Harnett County Government Complex  
307 Cornelius Harnett Boulevard  
Lillington, NC 27546

August 3, 2005

**Re: Status of Improvement Permit Application #05-5-12686  
Lt H-6 Carolina Seasons**

MILLENNIUM HOMES LLC.
Lot # 604 CAROLINA SEASONS
"The Cape with Sunroom"
1/4 = 10'

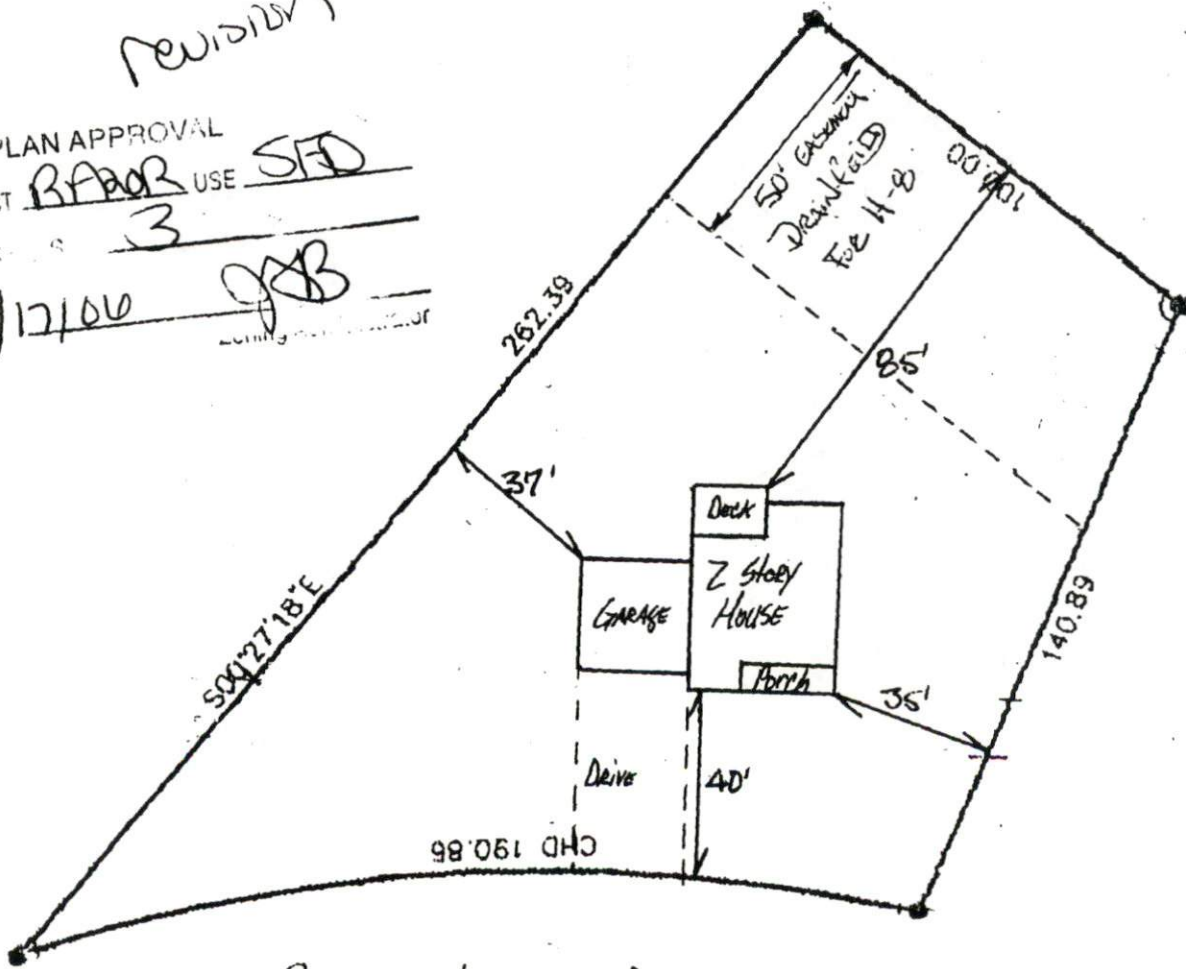
- 1. Property lines/corners not marked or labeled
- 2. House corners not marked or labeled
- 3. Directions not clear to property
- 4. Property needs brush or vegetation removed
- 5. Backhoe pits required
- 6. Other **There is a septic easement located on Lt H-6 (see enclosed map). Please locate the corners of easement and mark. Also note, that location of homes must be at least 5' from any drain field including, those on the septic easement. Please submit changes and map with easement to Central Permitting. Reconfirm through the automated phone system.**
